From: Both, Jason (Parks) <Jason.Both@PARKS.WA.GOV>
Sent: Thursday, April 25, 2024 8:47 AM
To: Bradley Gasawski
Cc: Griffith, Scott (PARKS); Graham, Ken (PARKS)
Subject: FW: SE-24-00013 Horish - Notice of Application

- 1) Have the landowners actions been approved through the Department of Ecology through a water mitigation plan?
- 2) Has the water conveyance been engineered?
- 3) Source of the water and potential future impacts?
- 4) The landowner should have an approved water mitigation plan through the Department of Ecology and the County.
- 5) This has been an ongoing issue with private property owners diverting their water flow onto State Parks property without approval from the Department of Ecology and State Parks.
- 6) The added water flow has caused flooding up against the Palouse to Cascades Trail (PTCT) which has caused erosion of the trail base in certain areas.
- 7) Recommend requiring the landowner to convey the water entirely on private property should the access be approved.

Subject: SE-24-00013 Horish - Notice of Application

GRADING PLAN AND STORMWATER MANAGEMENT

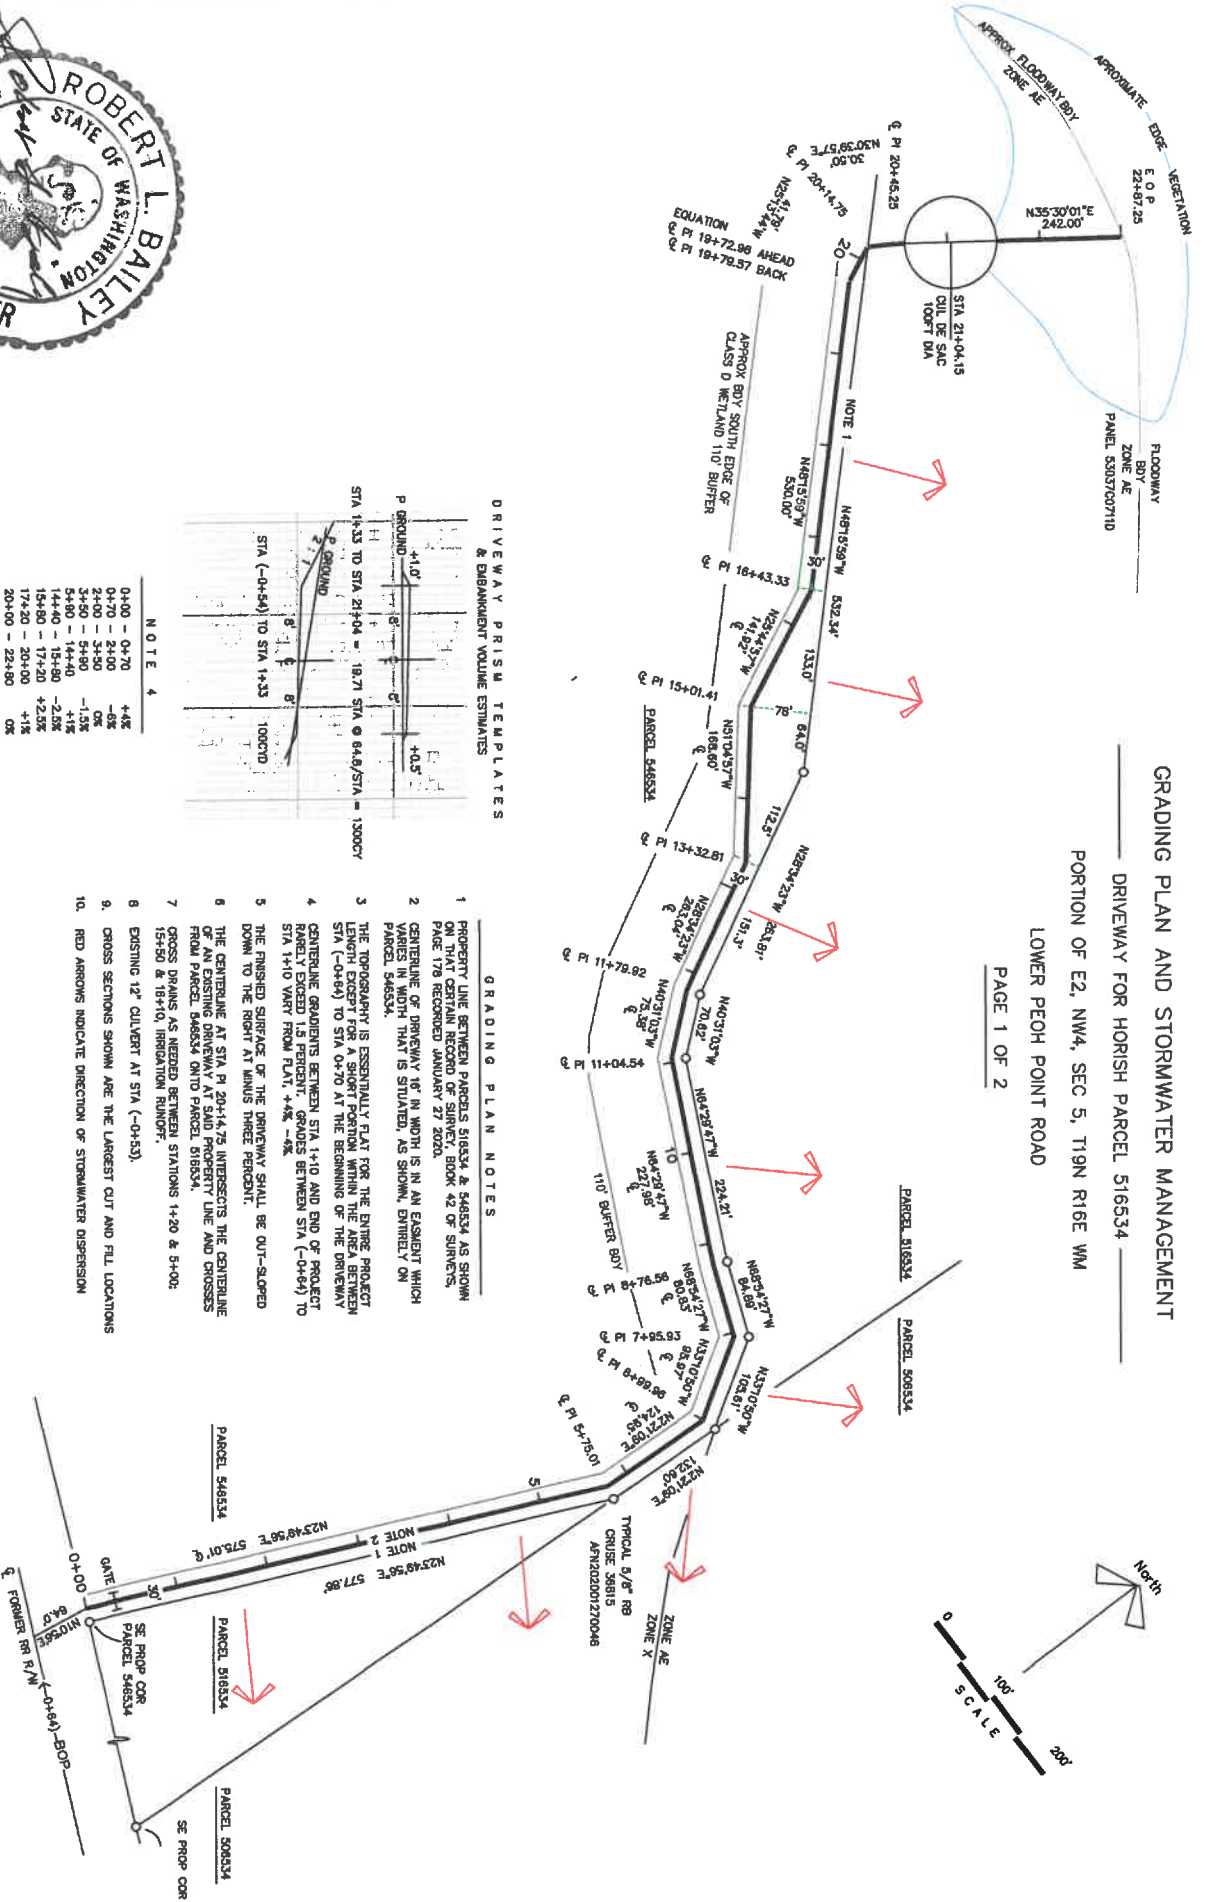
I have reviewed the SEPA checklist and associated documents. I have concerns regarding impact to park property and future maintenance requirements with the water conveyance at this location. The landowner has already diverted a flow of water from their property onto state property into existing drainage.
